Application No: AB/114/20/PD
Site Address: Riverside House 2 Fitzalan Road Arundel BN18 9JS
Description of works: Notification for Prior Approval under Schedule 2 Part 1 Class AA for a additional 2 storeys on existing dwelling house.

Thank you for your internet representation made on 28th November 2020 which has been recorded as an objection with the comments as follows:

Drawing Title:
PROPOSED ELEVATIONS

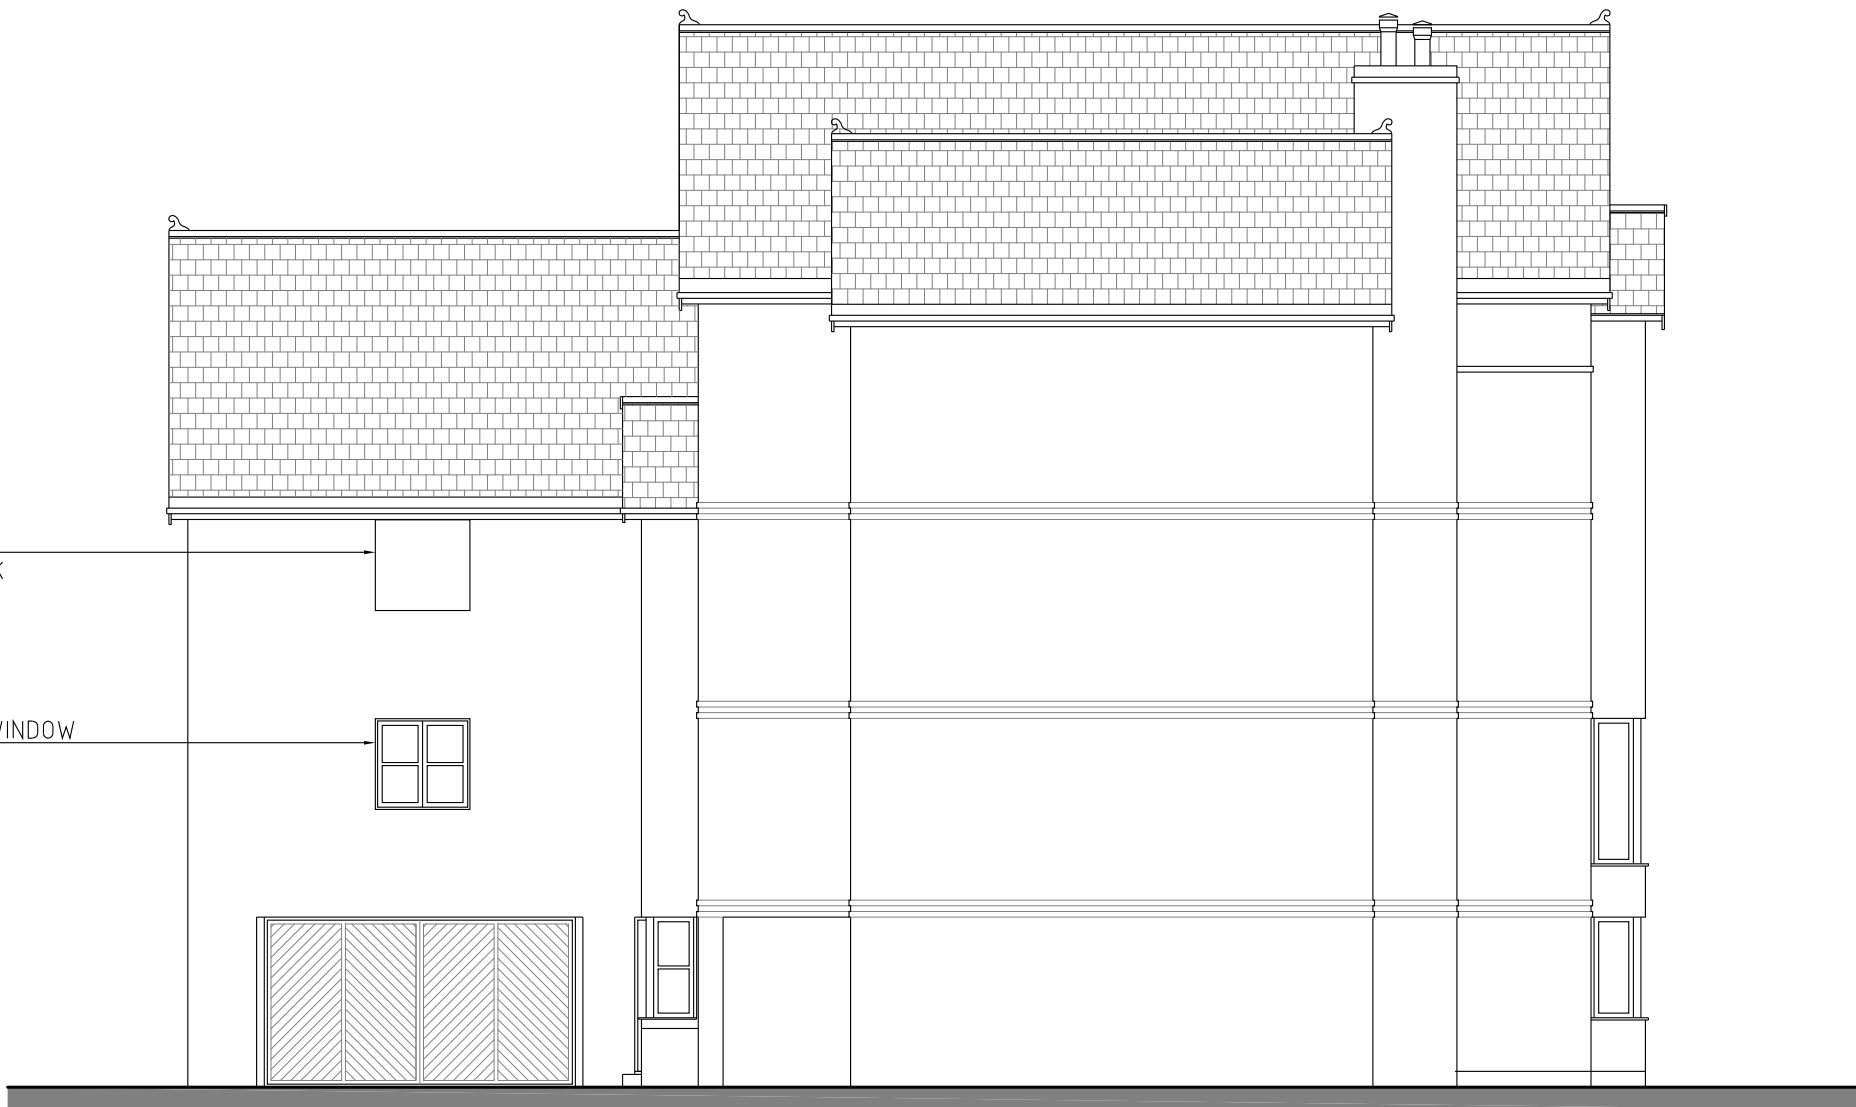
The property is set in an open and mostly suburban streetscape of small residential properties of one or two stories. Although it is bordered on one side by Martlets Court, there are no other single residential properties that extend to four stories anywhere in the vicinity. The proposed extension would make this property uncharacteristically tall, and a bulky inset that is out of keeping with the street scene.

The height and bulk of this proposed extension will directly impact neighbouring properties, causing loss of sunlight and privacy. Furthermore, whereas in the current situation there are mature and semi mature trees to provide some screening and privacy, the extension will be of such height that it will rise above the tree heights. As such it will be intrusive and dominate the immediate locality.

The bulk and height of the proposed extension would also negatively impact the conservation area on the North side of the River Arun.
